Recommendation Report for Planning Permission for Works or Extension to a Dwelling

REF NO: FP/32/22/HH

LOCATION: 8 Longport Road
Felpham
PO22 7JU

PROPOSAL: Erection of single storey rear extension.

DRAWING
PROPOSED PLANS

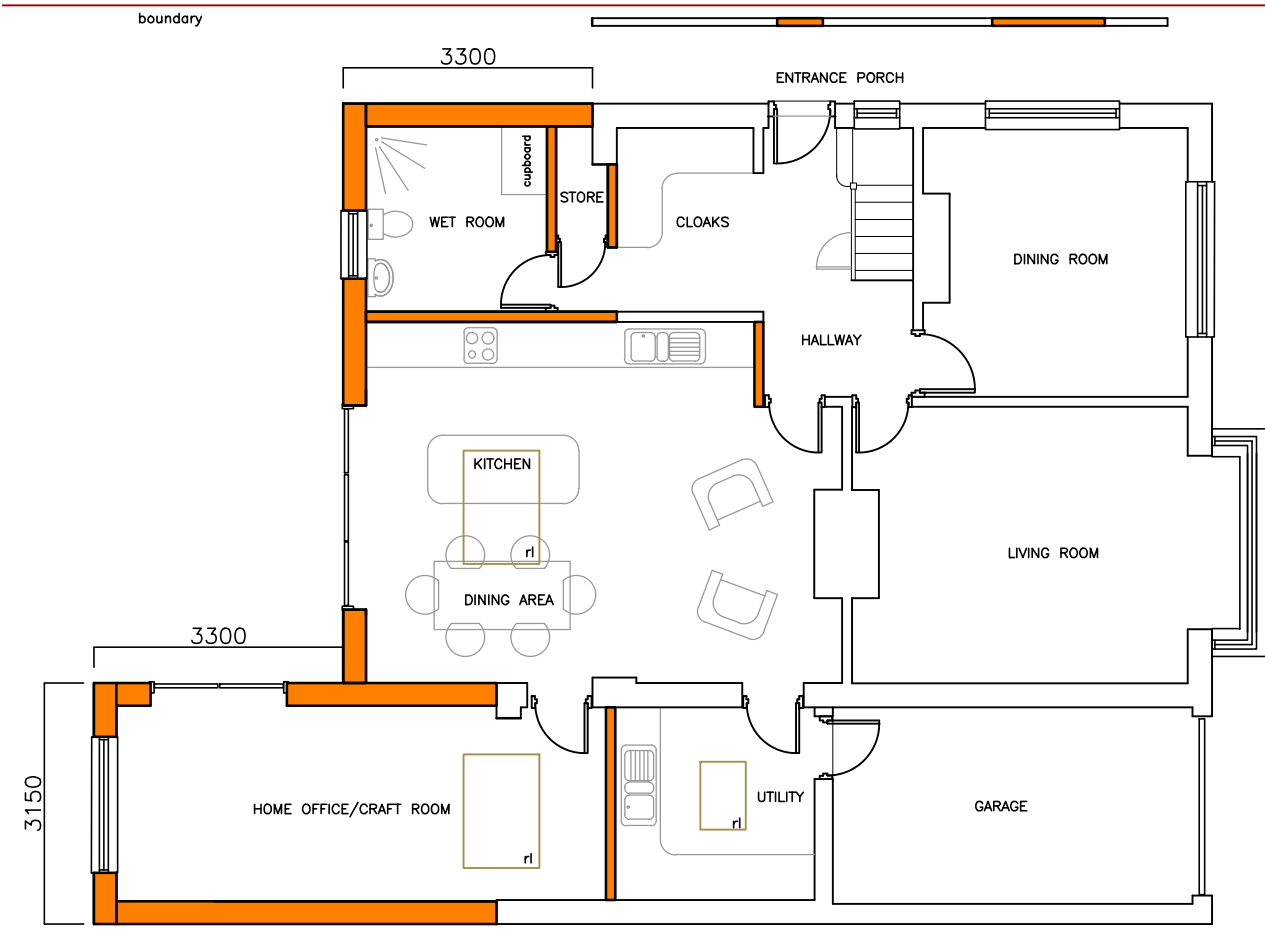
At present, there is an existing rear extension to the southern side of the property. The proposal will replace this, extending slightly further west, and will also include an extension from the rear elevation of the property. This will retain the width of the property, which is around 10.86m, with part of the extension projecting 3.3m, and the other 5.3m. It is a modest extension, and will have a low pitched lean to roof, which although not following the same angle as the existing, will not appear unduly out of place and is acceptable. Being to the rear, the proposal will not be visible from the street scene, and will have no impact on the composition or appearance of the area. The area itself is comprised of mainly detached two storey dwellings, with a mix of varied style and design. The proposal is in keeping with the general character of the area, and will have minimal harm on visual amenity.

The proposal is single storey, and will have a lean to roof with a height of approximately 3.06m, and 2.7m at the eaves. This roof will include three rooflights, all of which are flush and pose no risk of harm to residential amenity. It retains 1.2m to the north boundary, a minimum of 13.5m to the west and 0m to the south boundary. Arun Design Guide recommends the use of the 45 degree rule for detached properties, in order to assess any impact there may be on neighbouring properties. The extension does marginally conflict this line when taken from the rear of No.10, but this is very minimal and not of significant harm to residential amenity. Given the scale of the proposal, there will be no adverse overbearing or overshadowing of neighbouring properties No.6 and No.10, and as such is an acceptable development. It is in accord with D DM4.

DRAWING
**PROPOSED
ELEVATIONS**
DRAWING No
383/05
REVISION
SCALE 1:100
DATE FEB 2022
DRAWN LA
CHECKED

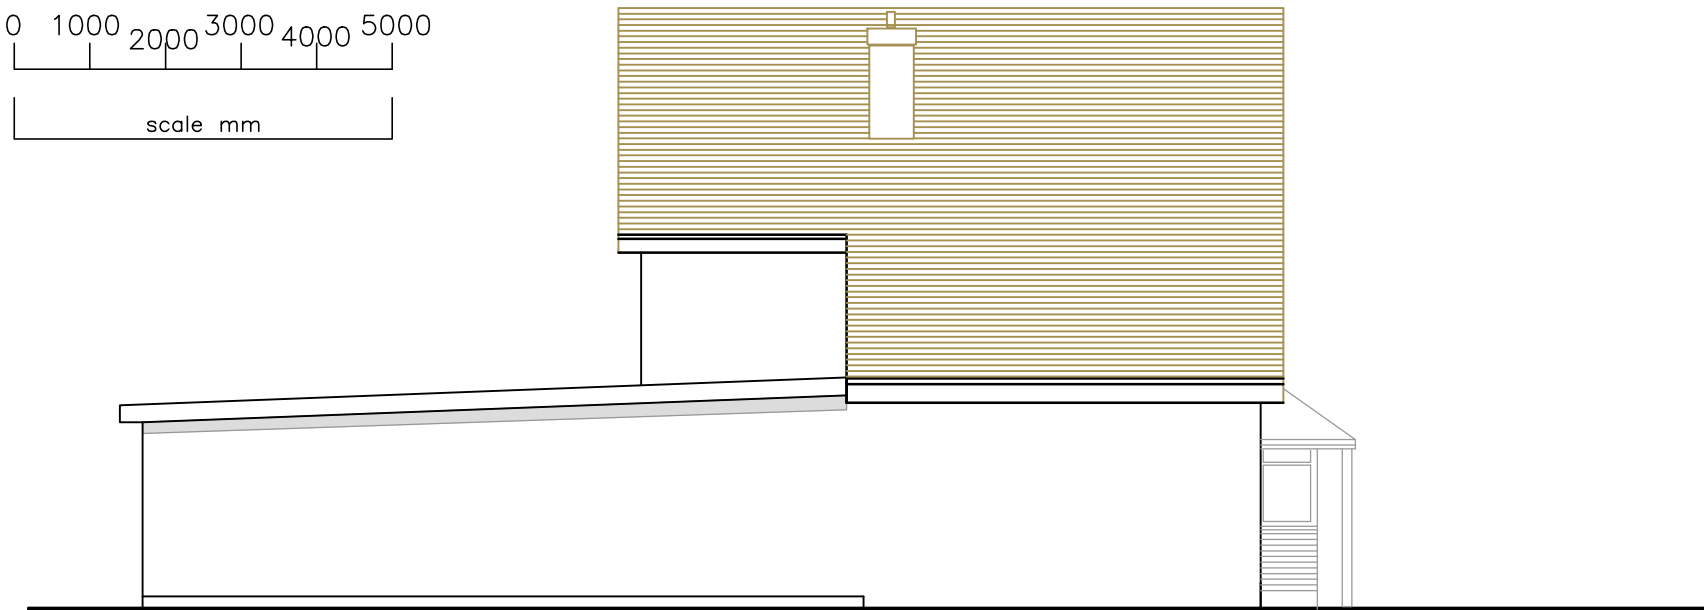
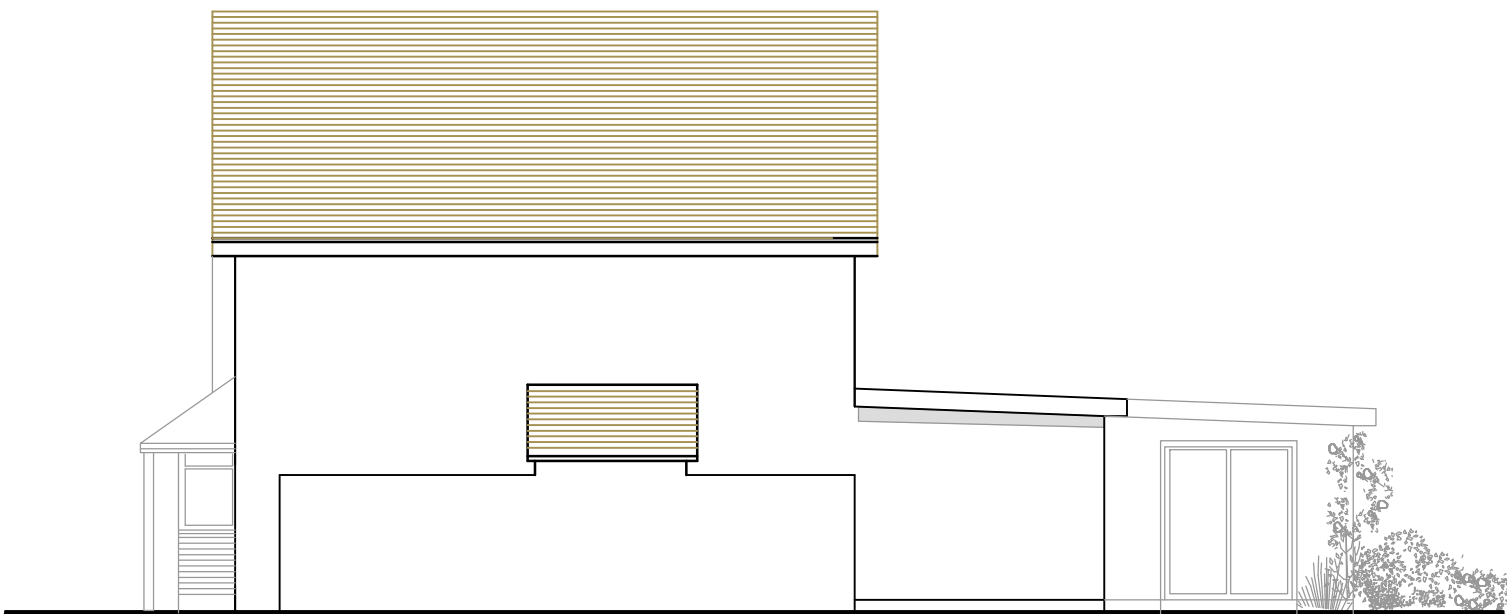
The proposal appears subservient to the design of the host and is well integrated. It will use materials matching the existing where possible, with the only exception being the GRP flat roofing system. This is acceptable, and will help to ensure there is minimal intrusion on the character and appearance of the property. The proposal is in accord with the Neighbourhood Plan, and will not have an adverse impact on the local character of the area.

Part M of the Arun Design Guide states rear extensions should respond to the distinctive characteristics of the building and surrounding area, preserve external garden amenity space and exploit opportunities for innovative and contemporary design where appropriate. Despite having a lower pitched roof than the host, the proposal integrates well with the existing, and will have little harm on visual amenity. It is in accord with Part M.

In addition to the rooflights, the extension will feature windows and doors to the west elevation, and doors to the north. These features will not unduly overlook any neighbouring properties, and are acceptable, posing no risk of adverse harm to residential privacy or amenity.
